Our Ref: Y/47/19/HH

**Town & Country Planning Act 1990 (as amended)
Town & Country Planning (Development Management Procedure) (England) Order 2015
Application for Planning Permission for Works or Extension to a Dwelling**

Development Single storey front extension, part two storey part single storey rear extension and alterations to fenestration.

Location Normandie Church Lane Yapton

PROPOSED SITE PLAN

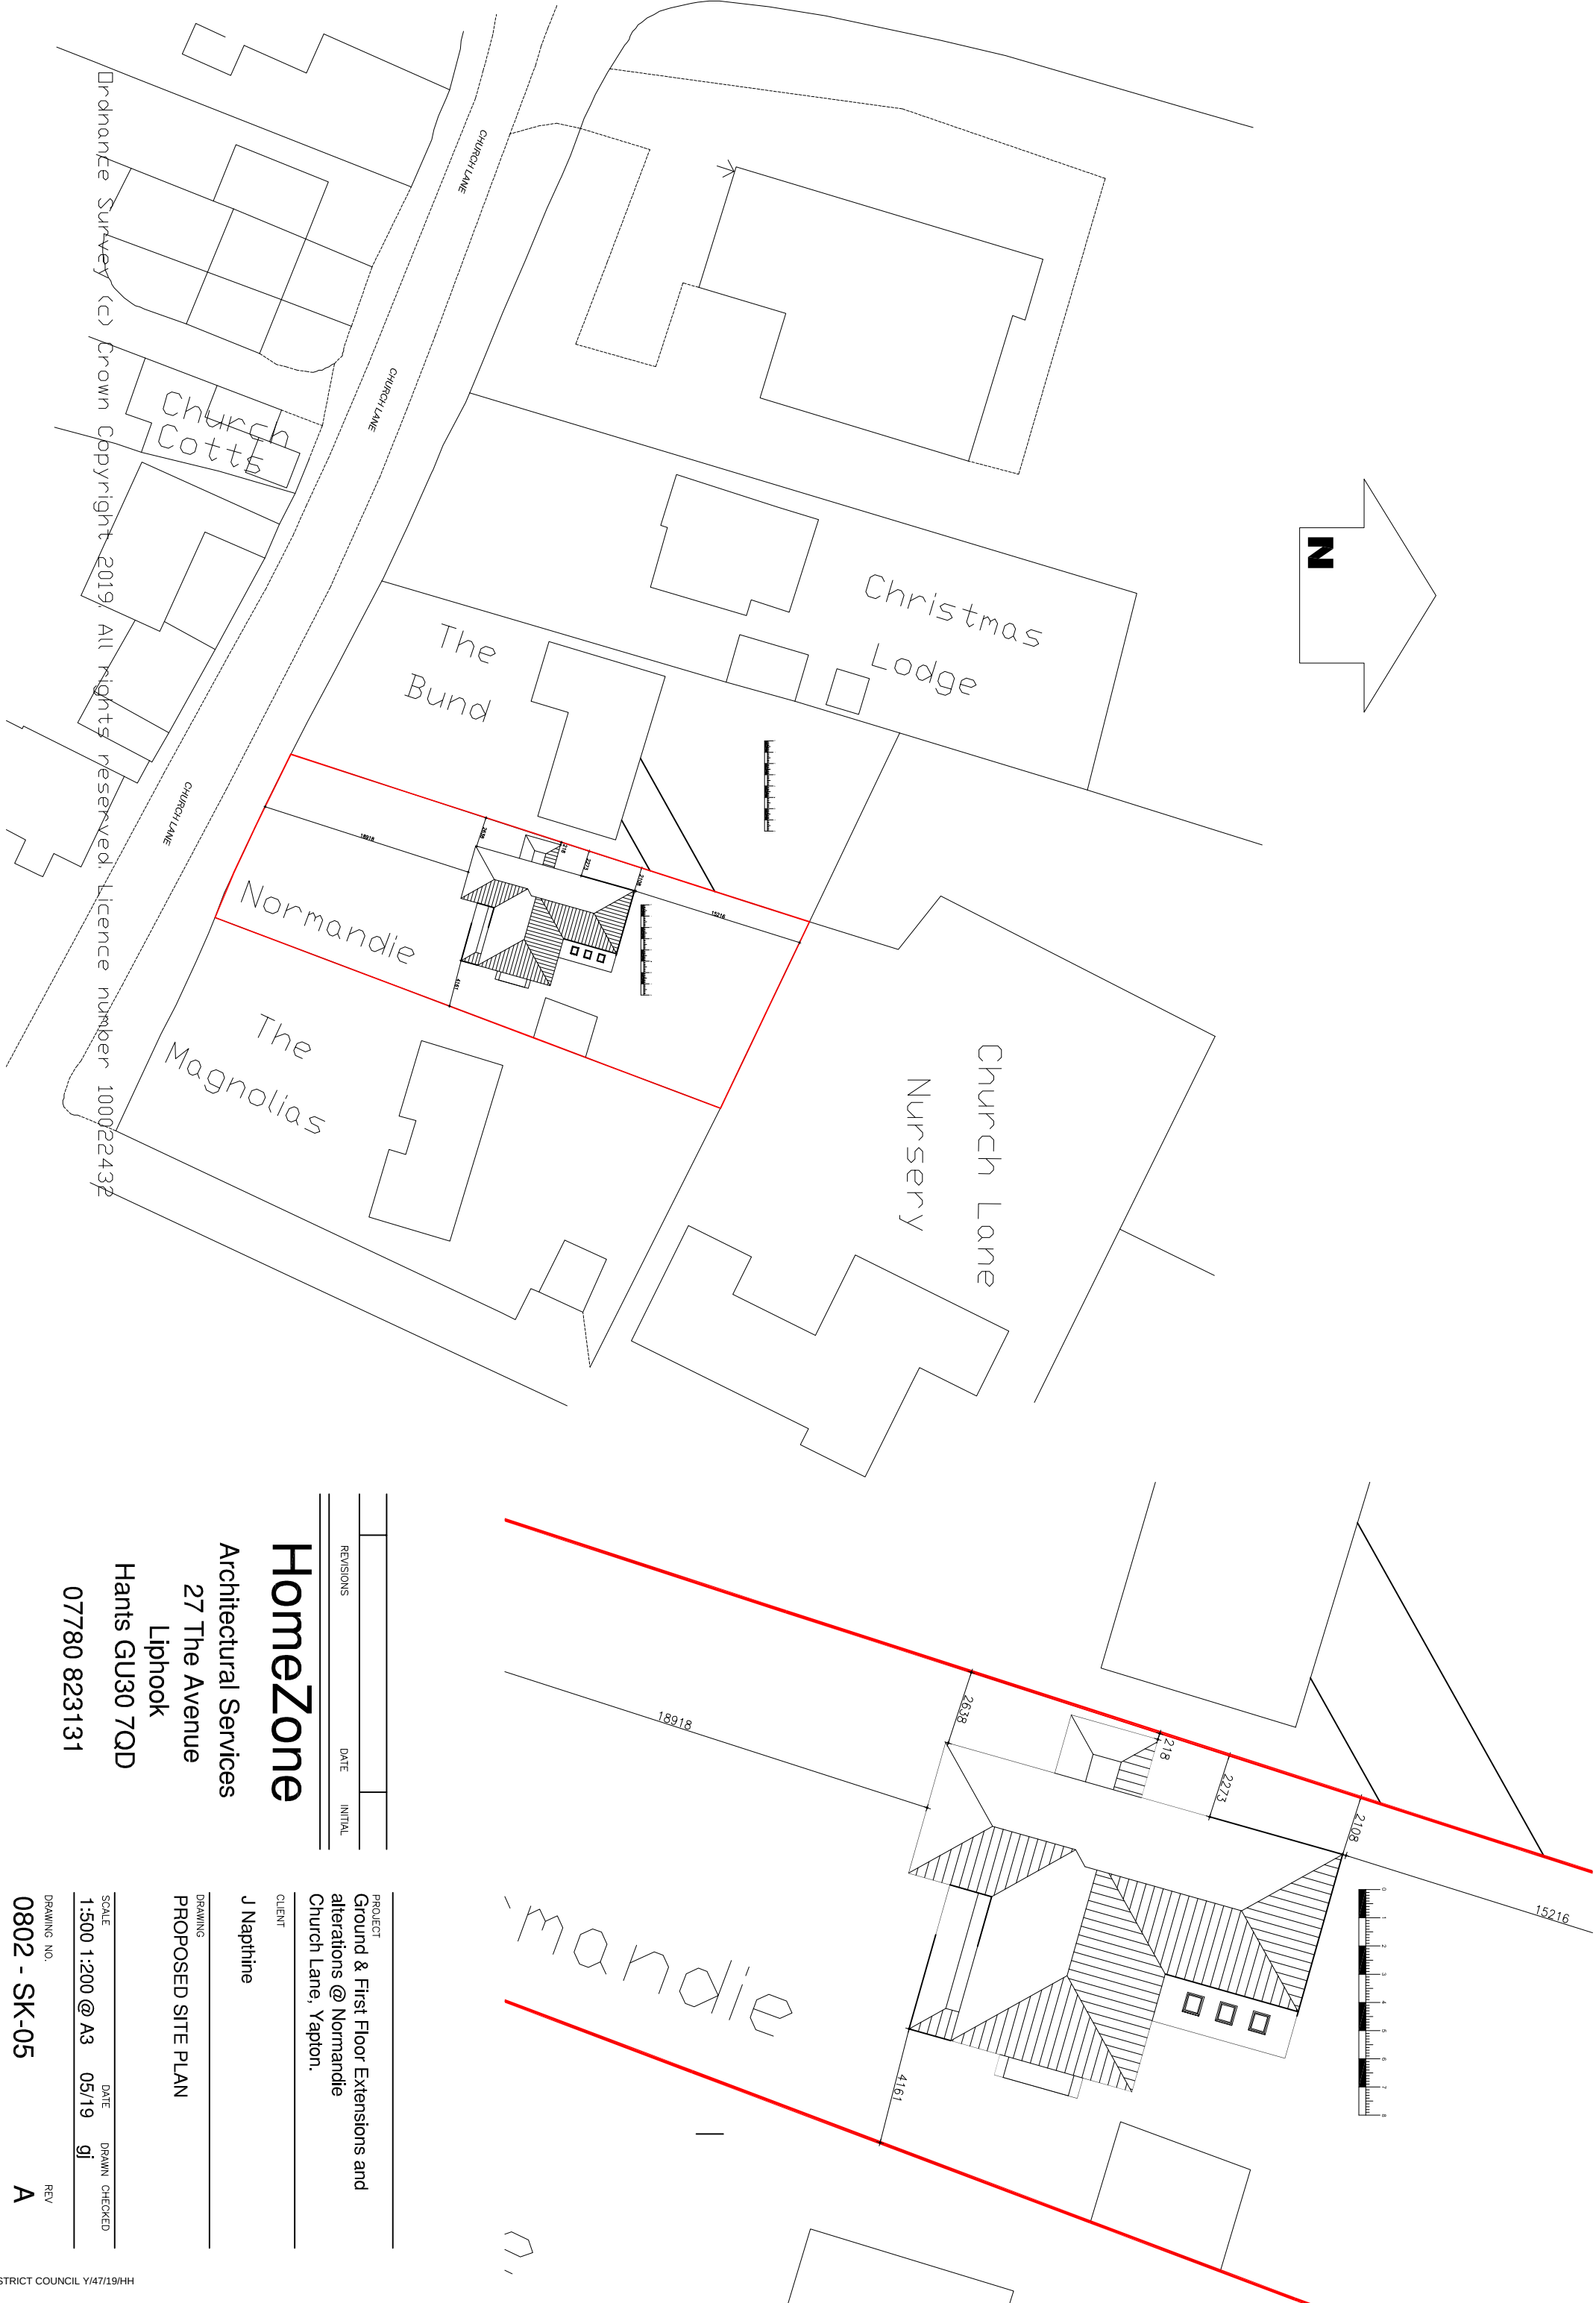
Block Plan

Please submit 1 electronic or 3 paper copies of a block/site plan which includes all dimensions from the proposed extensions to the site boundaries.
